Our Ref: 15756
DPE Ref: SSDA 7317 MOD 5

SSDA 7317 MOD 5 – RESPONSE TO SUBMISSIONS

This Response to Submissions (RTS) letter is submitted to the Department of Planning & Environment (the Department) in support of Modification 5 to amend State Significant Development (SSD) consent SSD 7317 relating to the construction of a commercial campus at the Australian Technology Park, Eveleigh.

1 TRAVELATOR TUNNEL - PLAN
1 : 100

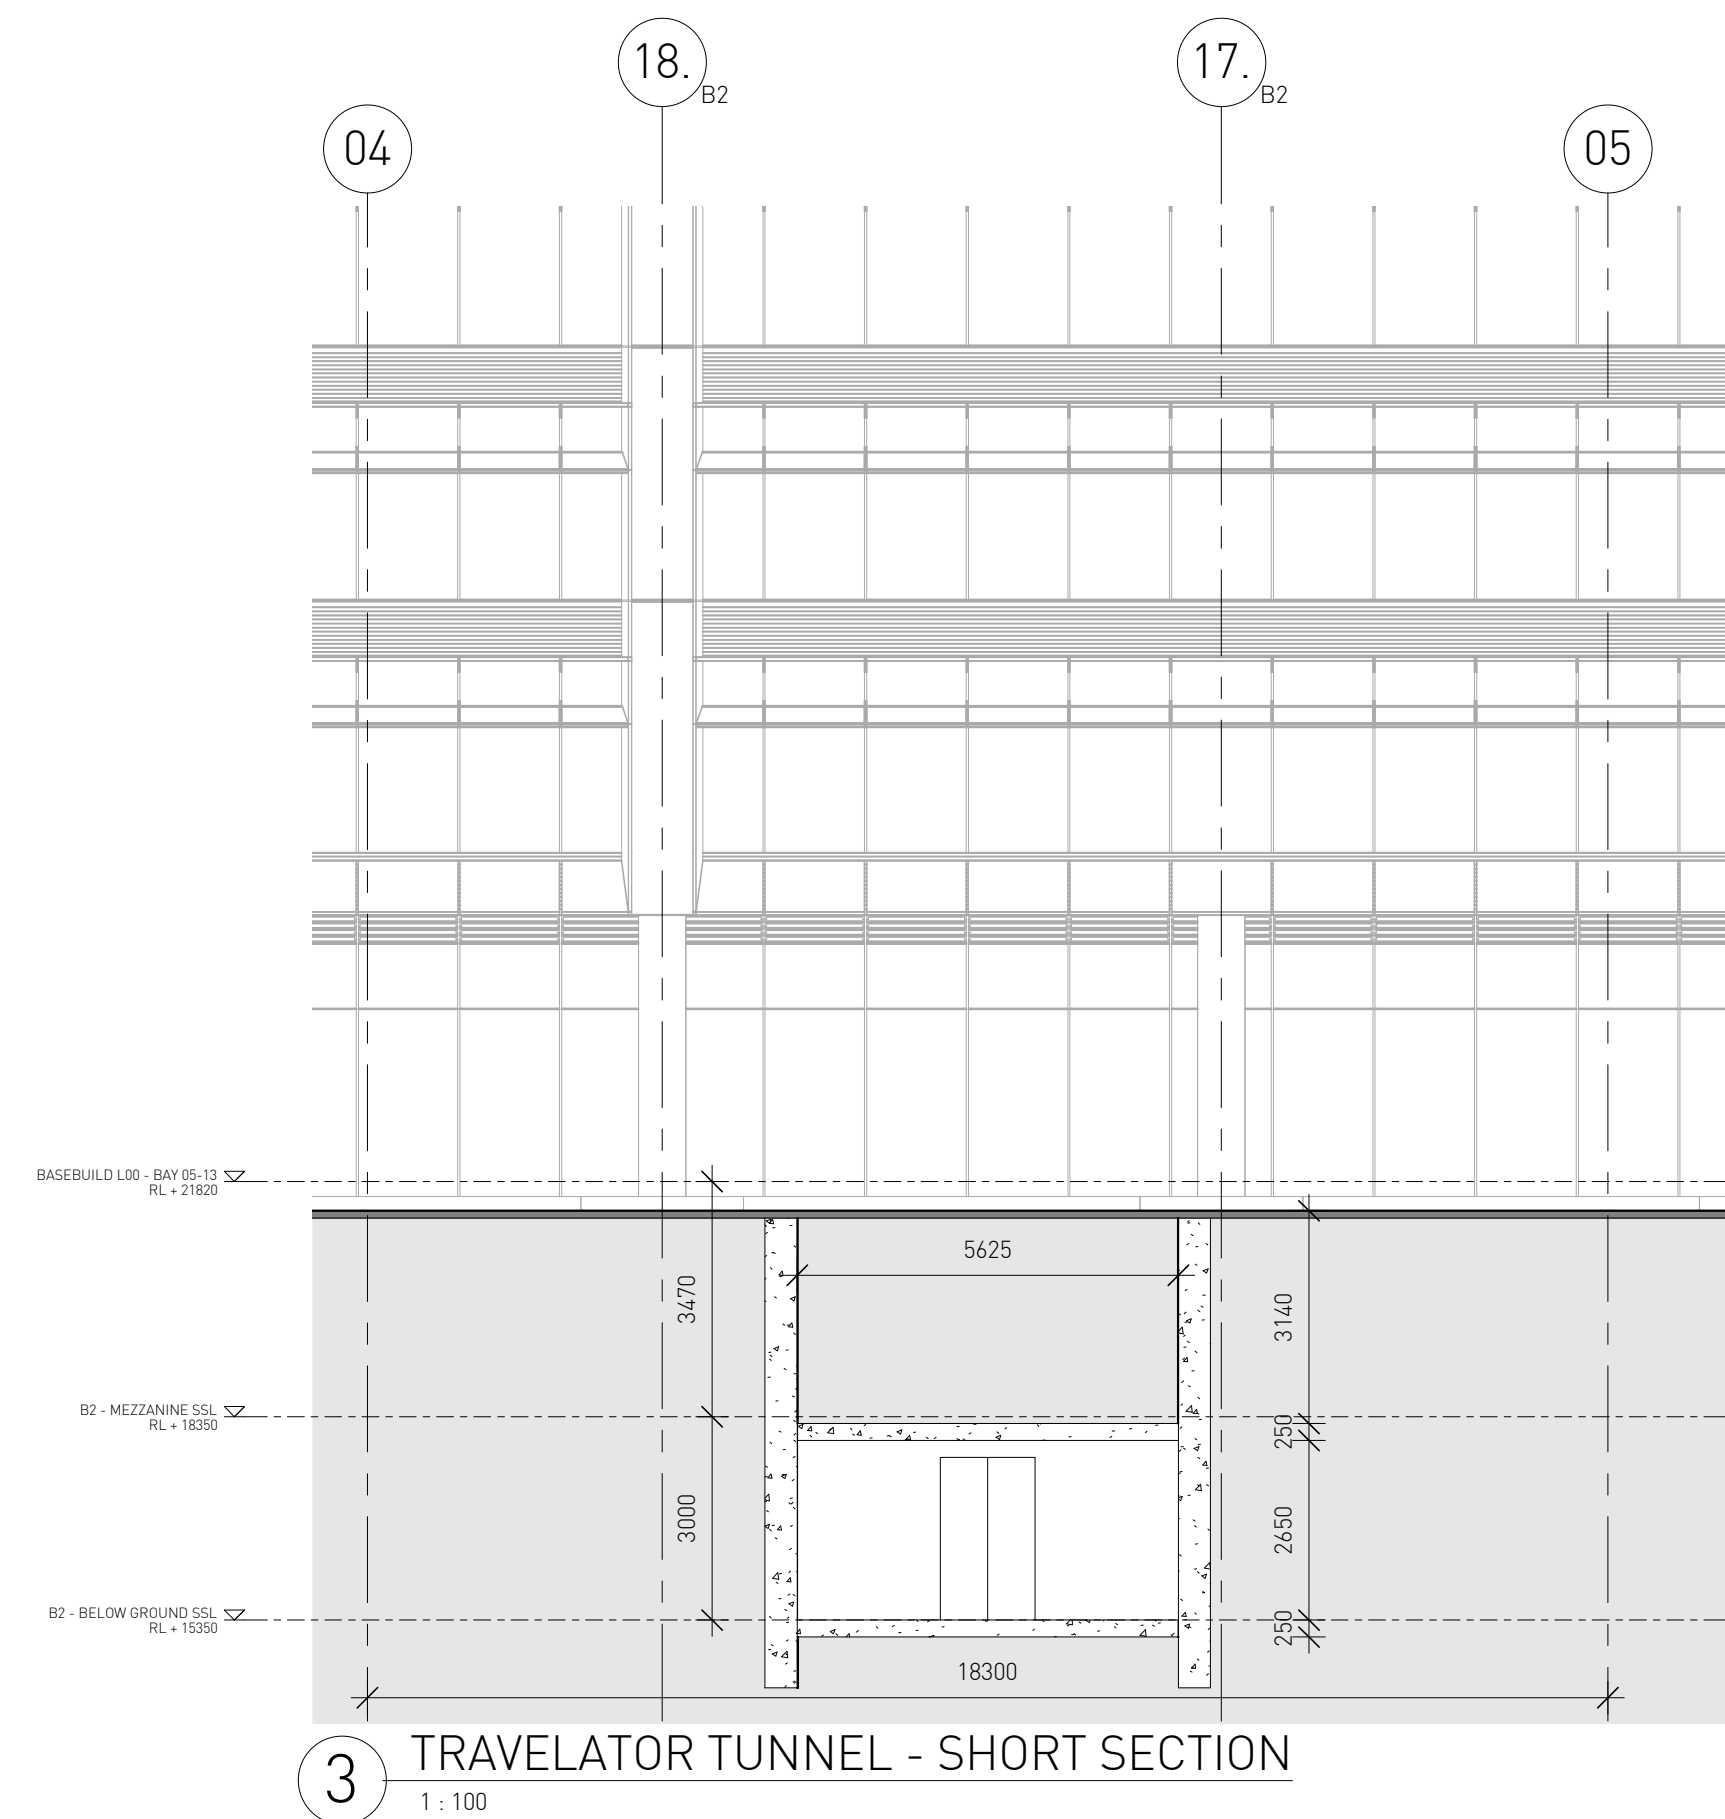
Provide justification for the need for the concrete base structure to be considered separately to SSD 8517, including details on the timing of the public domain works in Locomotive Street (SSD 7317) and future works associated with SSD 8517 if approved.

Provide plans/ details to demonstrate how the concrete base structure will be capped at the boundary between SSD 7317 MOD 5 and SSD 8517 as well as any interim works at the junction to the Building 2 basement.

During the construction works and until such time that the travelator is fully functional, the concrete base structure will be capped at the boundary between SSDA 7317 and SSD 8517 by hoardings and hoardings will also be used at the junction of Building 2.
